# DA ACCESS ASSESSMENT REPORT

## *Selleys Warehouse & Laboratory*

Project Number: 119445

Date: 1 November 2024

DETAIL FLOOR PLAN - OPERATIONS OFFICE + TECHNICAL CENTRE - GROUND SCALE: 1:200

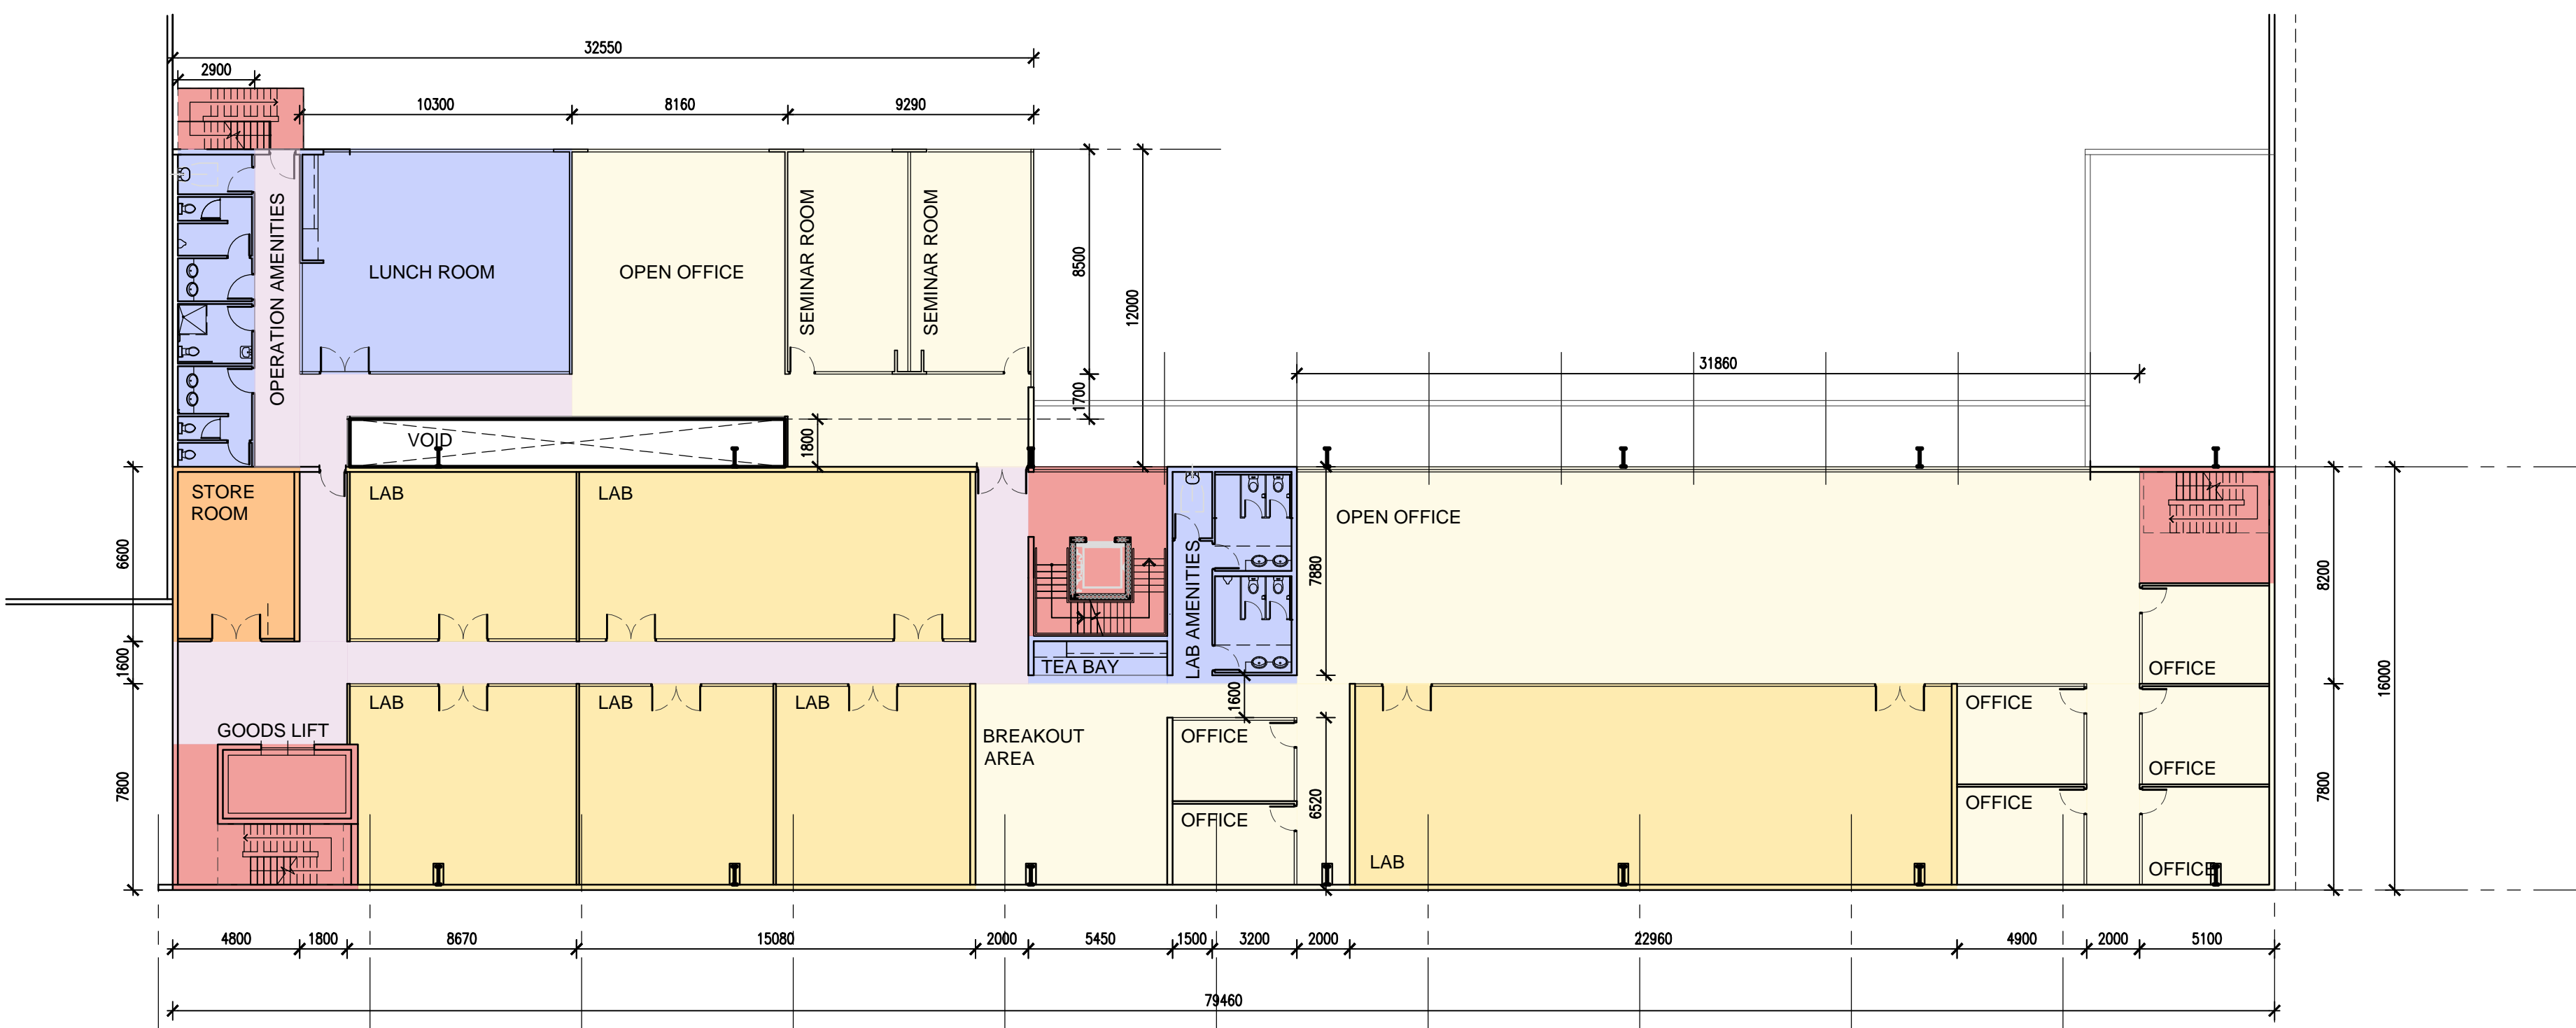
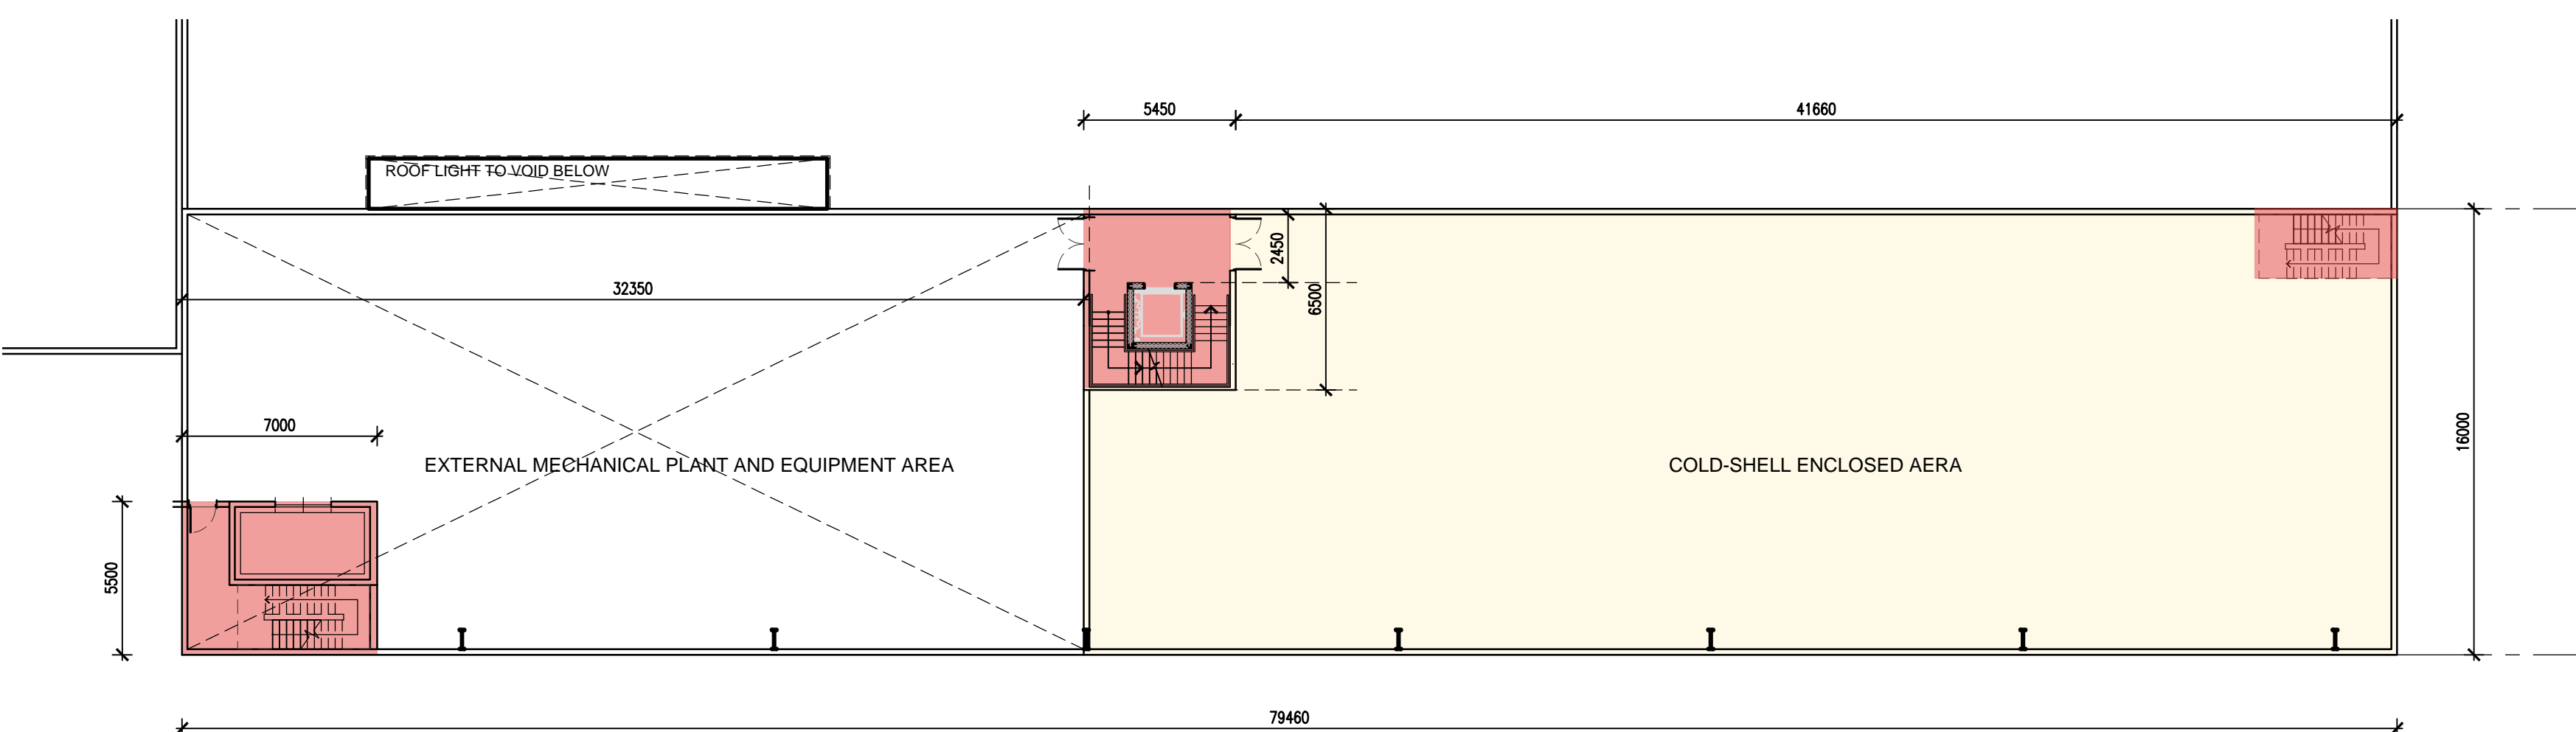
The non-fire-isolated stairway to the office is required to be provided with handrails on both sides of the stair. Each fire-isolated stair in the office is required to be provided with offset risers throughout the stairway to ensure consistent handrail heights.

The following doorways are required to be updated to achieve the required doorway circulation clearances in accordance with AS1428.1-2009:

Ground Floor:

- Northern Office

- Central Corridor

First Floor:

- Southern Corridor

It is noted that the non-fire isolated stairway requires handrails on both sides of the stair, whereas only a single handrail has been provided. Plans will need to be updated accordingly.

A stairway platform lift is proposed at the building entry which would not comply with the provisions of this clause as the building serves more than 100 persons.

It is required that a passenger lift is provided.

Accessible Unisex Sanitary Compartments are required at each bank of toilets.

They have not been provided at the central bank of toilets on Ground Floor & Level 1 and will be required.
